# CITY OF ALBUQUERQUE

May 7, 2018

**RE: 211 Maple Ave NE**  
**Grading and Drainage Plan**  
**Stamp Date: 02/28/18**  
**Hydrology File: K15D090**

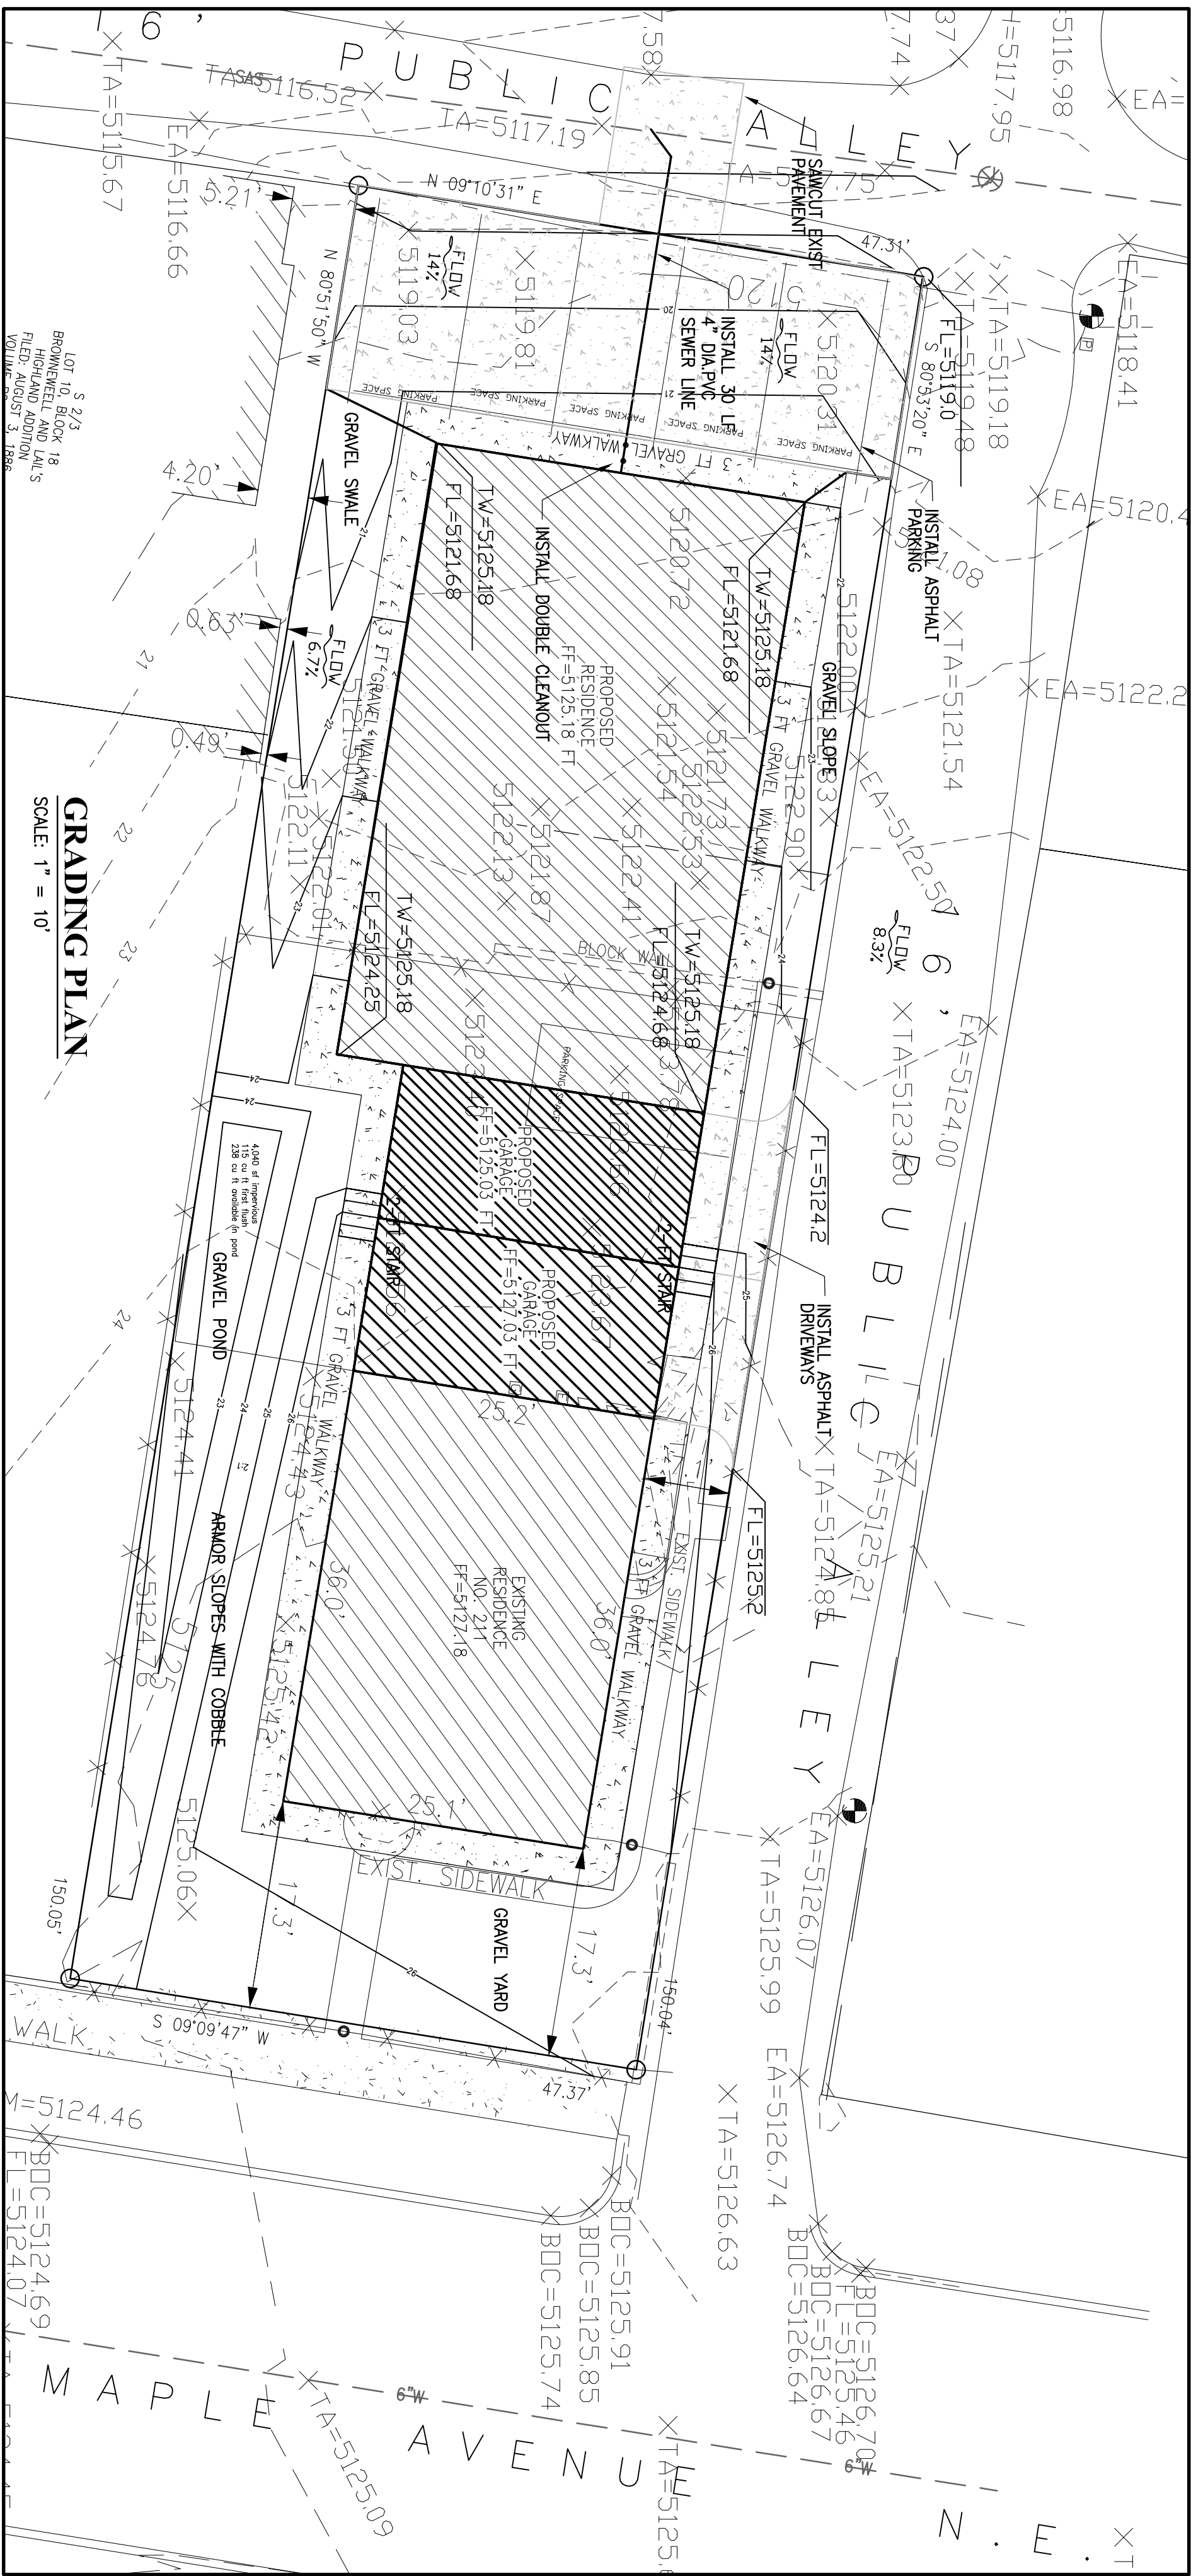
1. Per the DPM Chapter 22 Section 7, 24"x36" is currently the City's standard. This applies to all site plans, Grading & Drainage Plans, Traffic Circulation Plans, DRC Plans etc. Please always submit this size plan and not 11x17. 11x17 is too small for review purposes.
